Turning to your Policy and Public Health comments and your suggested reason for refusal (i.e. based on distance to Oakhill Primary Academy). I have had an opportunity to review these. I can see that these accept that the Council's PAN focuses on secondary schools and acknowledges that this site is not within walking distance of any secondary schools or other places where children and young people congregate. I understand the objection is based on the new NPPF (2024), which restricts hot food takeaways that are: "*within walking distance of schools and other places where children and young people congregate*".

Transport Comments

Yorkshire Water Comments

Title: **Private Drainage Layout**

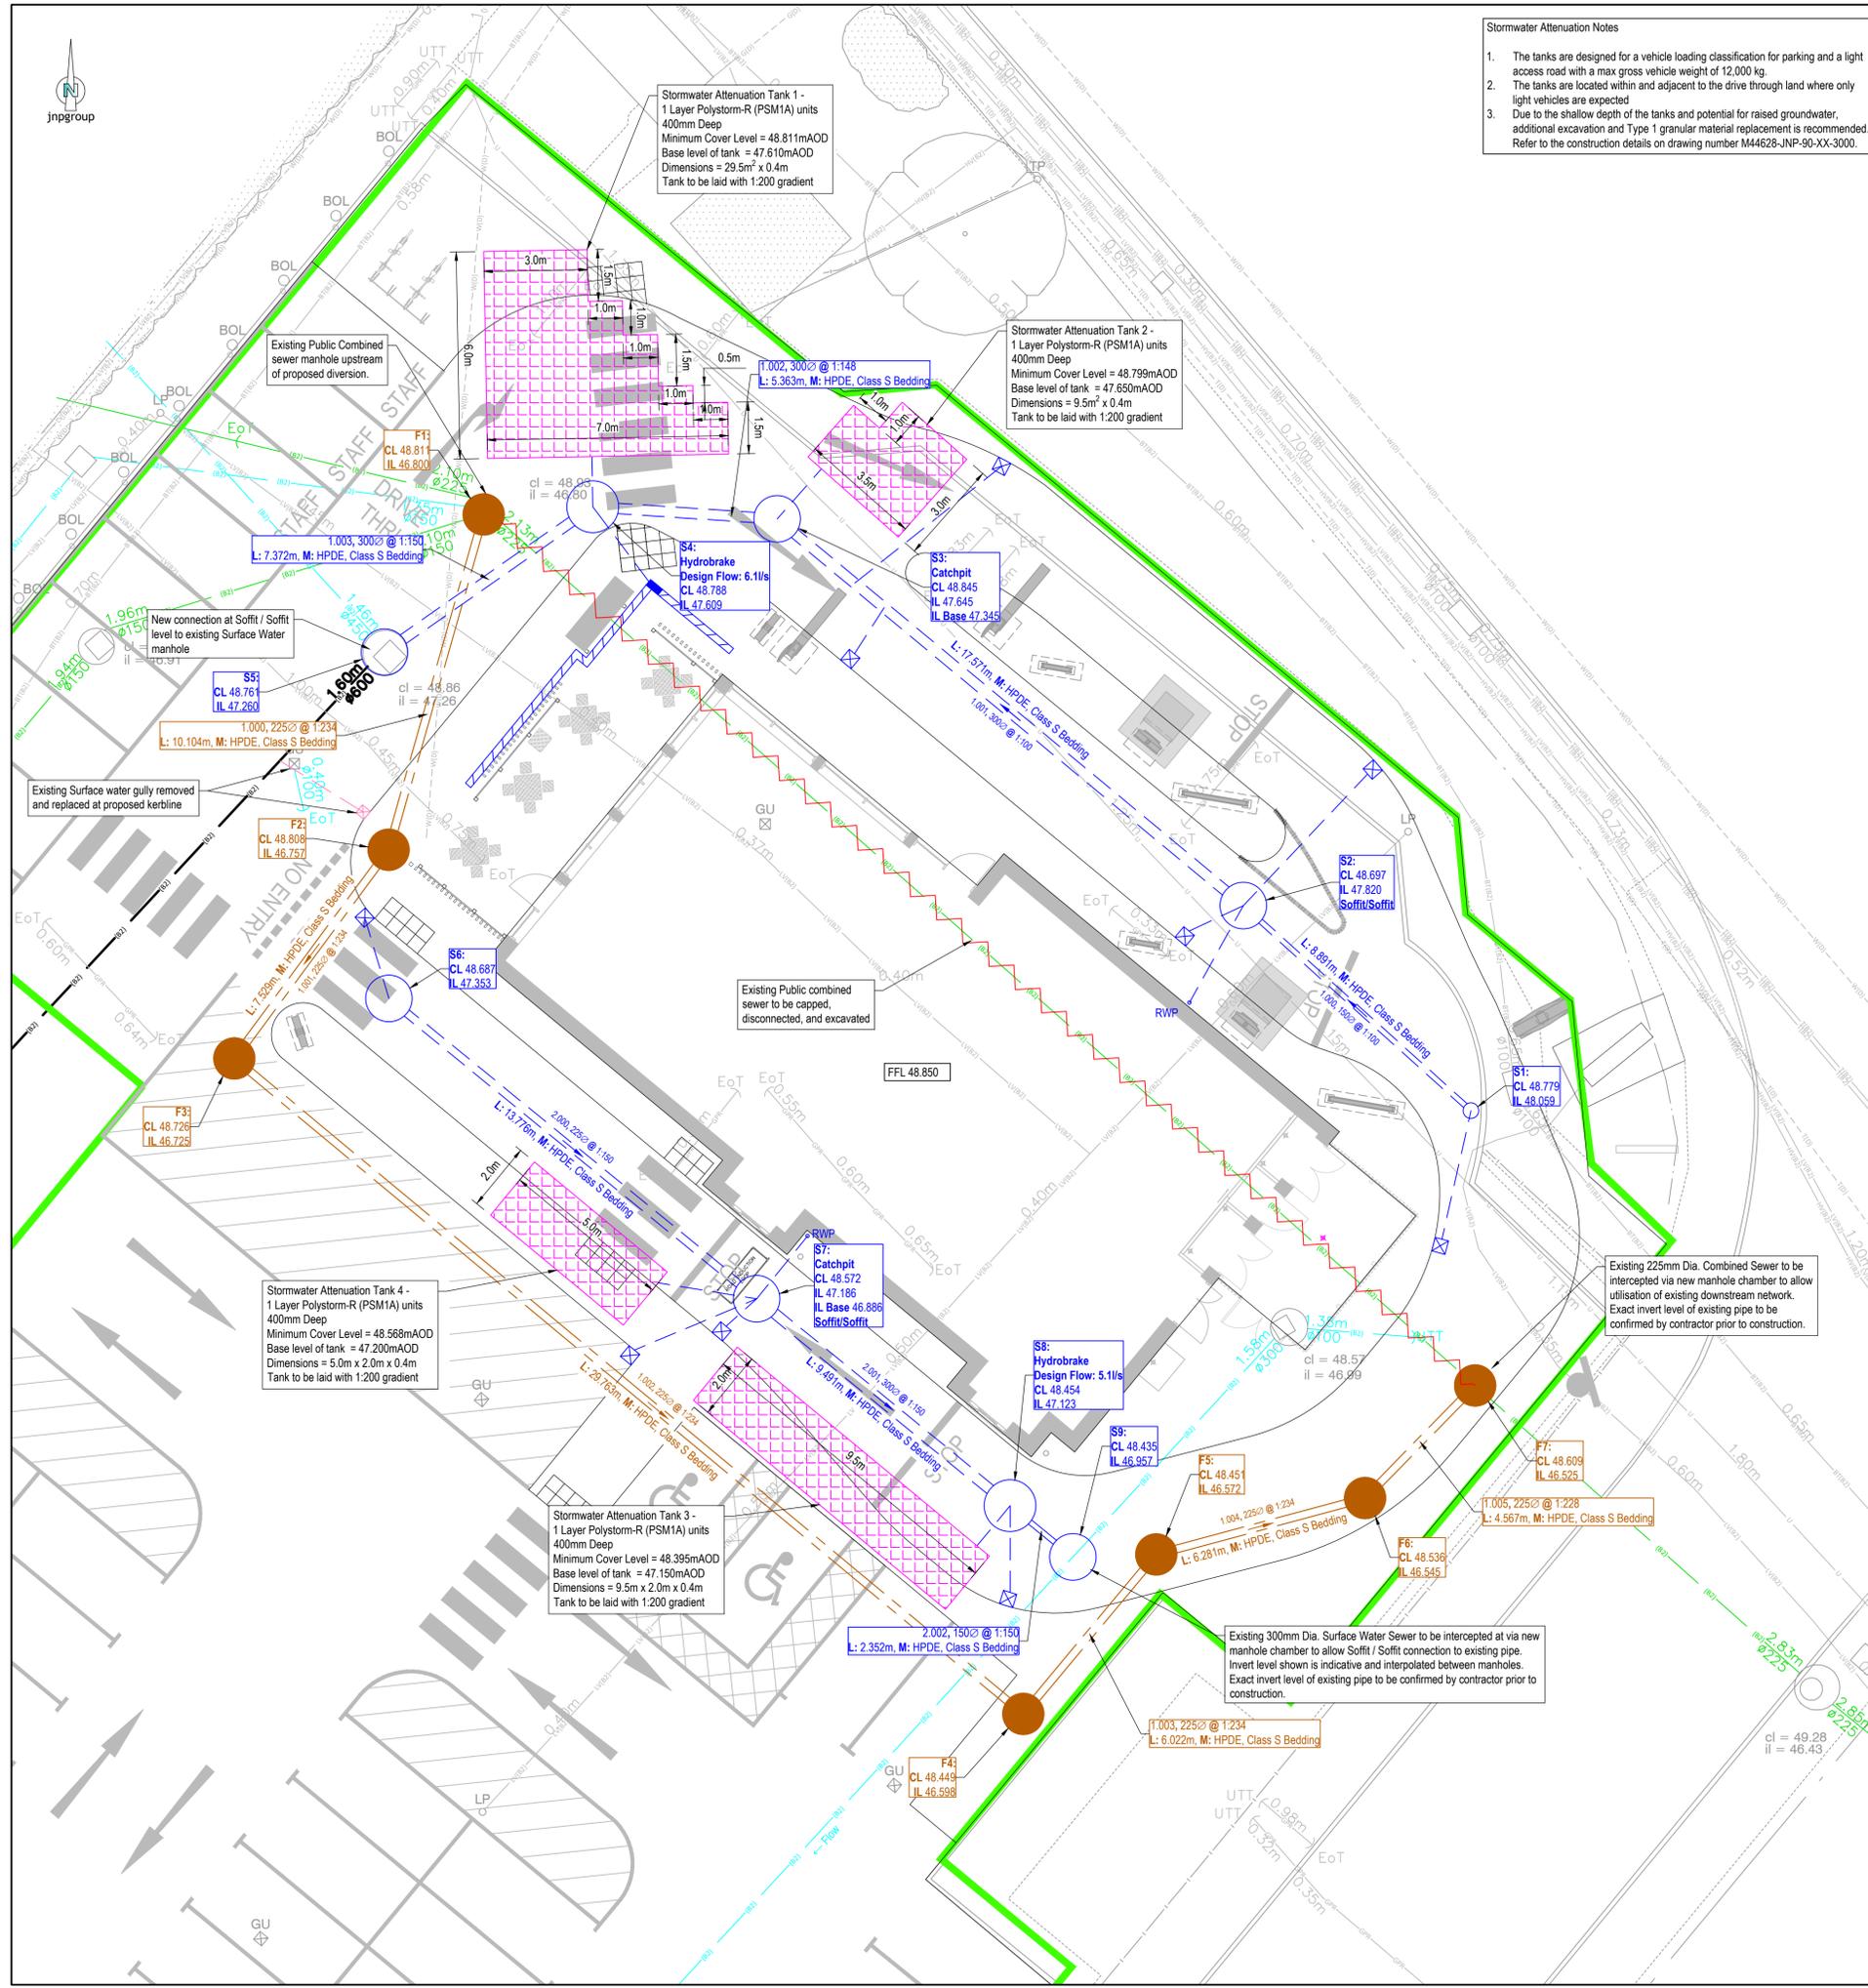
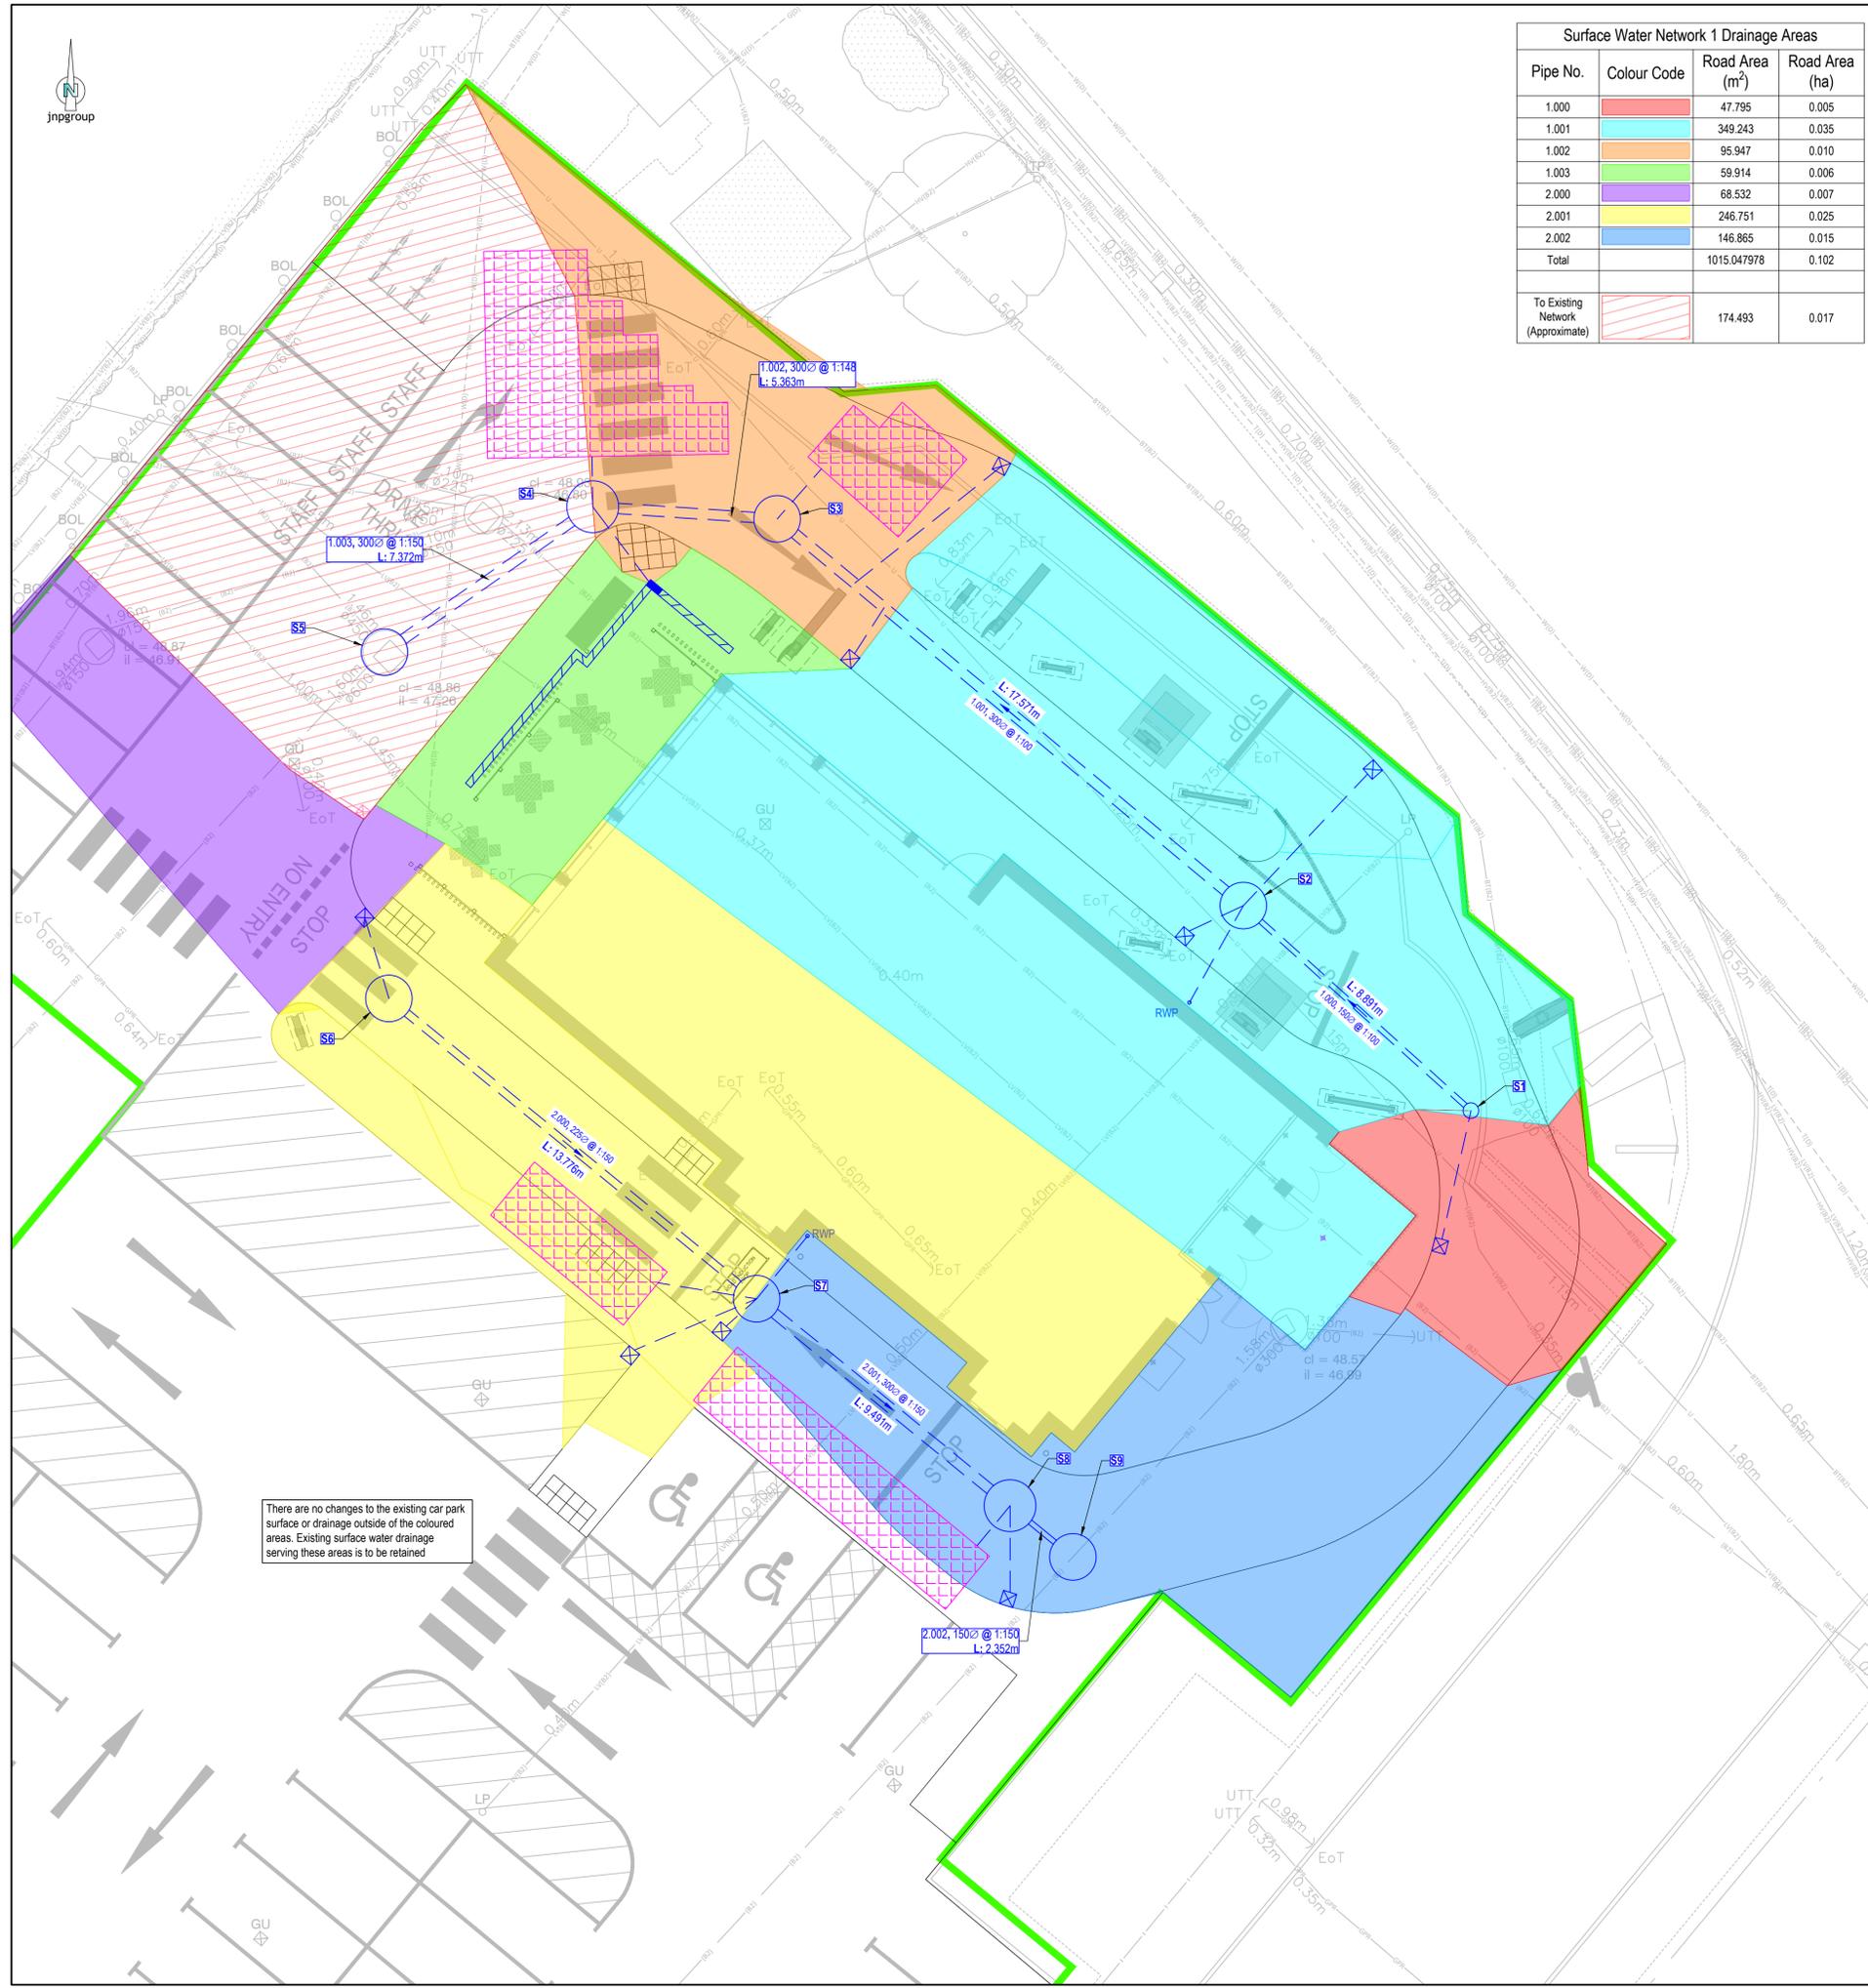
I can confirm that our engineers have spoken with Yorkshire Water and confirm all points should be resolvable. They have already prepared an updated drainage statement, layout, and flow control details with revised calculations to reflect a 1 in 1 year storm event. I attach these to this email.
